PEER REVIEW STATEMENT

ATTENTION:	Tegan Cole, NSW Dept of Planning Industry and Environment (DPIE)	
FROM:	Hugh Middlemis, Principal Groundwater Engineer, HydroGeoLogic (HGL)	
REFERENCES:	7 October 2021	Mount Pleasant Optimisation Project (SSD 10418)(EPBC 2020/8735)
SUBJECT:	Mount Pleasant Optimisation Project Rehabilitation and Mine Closure. Targeted Peer Review of the Groundwater Impact Assessment Final Void Issues.

This brief report presents the outcomes of a targeted peer review on the post-mining final void issues described in the Groundwater Impact Assessment ('GIA'; AGE 2020a), presented as Appendix C to the Mount Pleasant Optimisation Project EIS (SSD 10418) (MACH Energy 2020a).

MACHEnergy MOUNT PLEASANT OPTIMISATION PROJECT Conceptual Final Landform

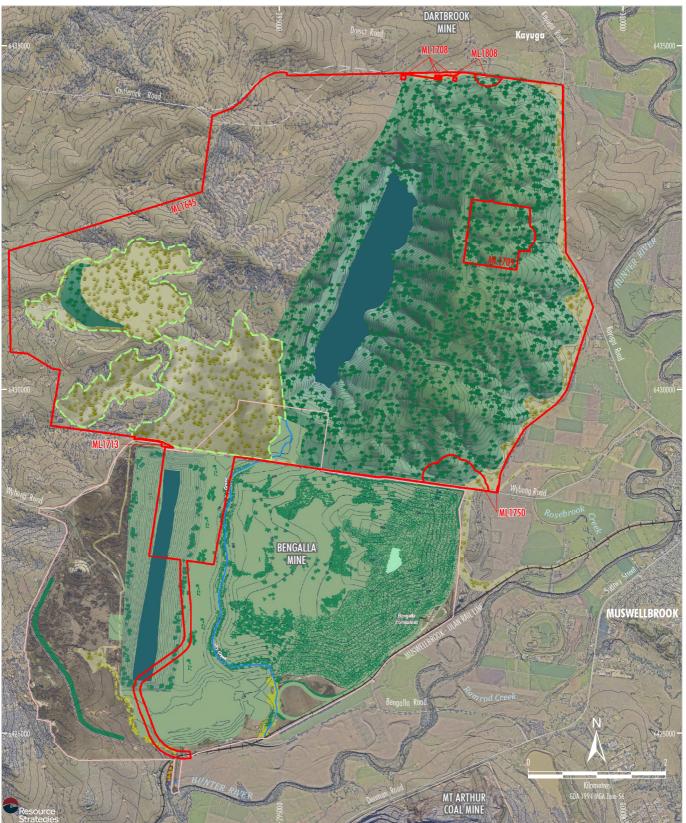
It is understood that the existing approval is based on a final landform with multiple voids, whereas the proposed final landform for the Mt Pleasant Optimisation involves a single void (Figure 1). The final void will receive groundwater and surface water inflows and will develop into a final void lake with a predicted water level of 80 or 90 mAHD. Predictions indicate that a final equilibrium would be achieved after around 300 years once there is a balance between the groundwater and surface water inputs and the lake evaporation output.

While the groundwater modelling details presented in the Groundwater Impact Assessment ('GIA'; AGE 2020a) are adequate and demonstrate consistency with best practice guidelines in general, the EIS report (MACH 2020a) and the supporting technical appendices present conflicting information on the long term lake level. The EIS states at section 7.8.3 (p.7-59) that the final void lake level is predicted to be 90 mAHD and illustrates this at Figure 7-16 (consistent with Figure 1 above). Figure A4.2 of the GIA also shows the final void lake level at 90 mAHD, but the similar Figure 30 in the Surface Water Impact Assessment ('SWIA'; HEC 2020) shows the predicted final void lake level at 80 mAHD (Figure 2). This inconsistency should be resolved.

The proposed single final void is deeper because the mining extends to deeper coal seams, which is more likely to result in a long term groundwater sink, as is reasonably predicted. Whether or not the proposed single final void will result in an improvement in water quality terms, compared to the multiple voids, is a complex question. It is not possible for this review to provide a definitive comparison, as that requires assessment of the catchment runoff inputs as well as the groundwater inputs and the evaporation effects, and a geochemical assessment. Nonetheless, this review considers that the final void lake water quality and geochemistry assessment is deficient in the sense that comprehensive details are not provided to clearly establish whether or not the final void lake would form a long term 'non-polluting' landform.

- rationalise the conflicting information on the long term lake level (80 or 90 mAHD?);
- provide a sound explanation as to why the groundwater level versus inflow relationship that is used in the GoldSim analytical water and salt balance modelling (HEC 2020) is valid in showing increasing inflows between zero and about 50 mAHD, under conditions when the driving head for inflow is falling and thus inflows should be reducing; the explanation should also address why the maximum post-mining inflow is more than 1.5 times the maximum inflow predicted during mining;
